**KIRKLEES METROPOLITAN COUNCIL
INVESTMENT & REGENERATION SERVICE**

DELEGATED DECISION TO DETERMINE PLANNING APPLICATIONS

Reference No:	2024/62/90283/W
Site Address:	5, North Carr, Dalton, Huddersfield, HD5 9QP
Description:	Formation of vehicular access and car parking area
Recommending Officer:	Laura Yeadon

DECISION – Conditional Full Permission

Tarmac Hardstanding Parking Area

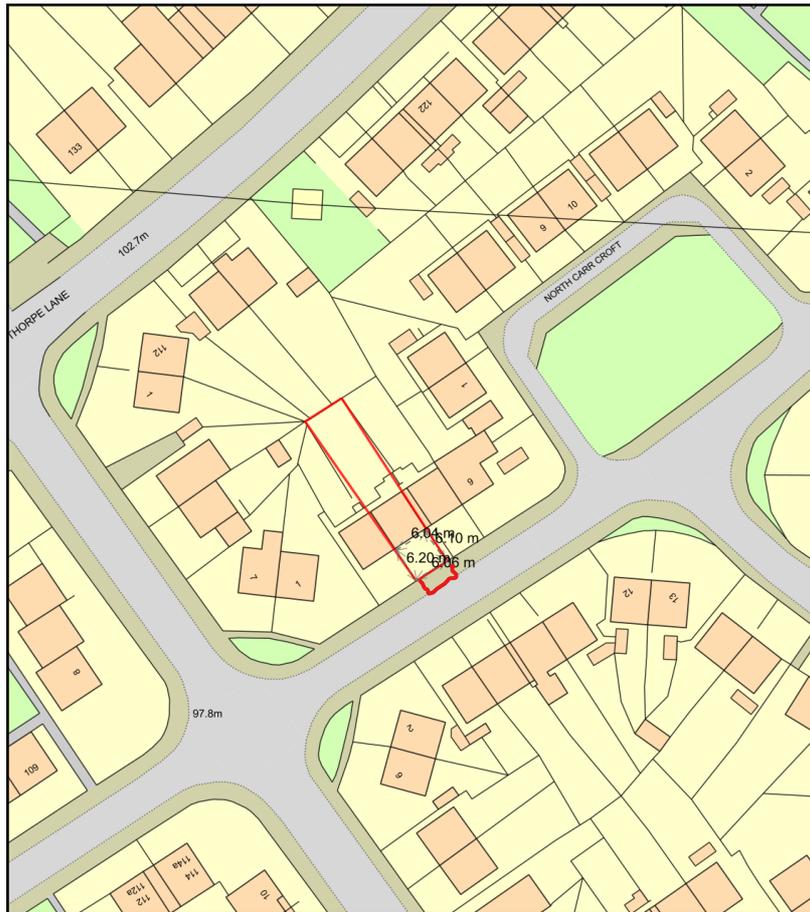
It is proposed that the front garden would be tarmacked to create a hardstanding area for the car parking area. The submitted plan indicates that the area to be tarmacked would be approximately 6m x 6.2m.

Drainage – the application proposes tarmac as the finishing material for the car parking area. It is noted that tarmac is not a permeable surface. Due to the risk of increased flood risk through surface water run-off it is considered reasonable and necessary in this instance to impose a condition on the decision notice stating that the surface should be designed in accordance with DCLG guidance on the permeable surfacing of front gardens to prevent flood risk through surface water run-off as noted above in the assessment on highway safety. This would also be in compliance with Policy LP28 of the Kirklees Local Plan and highway safety Policy LP21 as well as advice within the NPPF alongside Key Design Principle 14 of the House Extensions and Alterations SPD.

3. Notwithstanding the information within the application form, the formation of any parking area between the front elevation of the dwelling and the highway shall be drained and surfaced in accordance with the Communities and Local Government; and Environment Agency's 'Guidance on the permeable surfacing of front gardens (parking areas)' published 13th May 2009 (ISBN
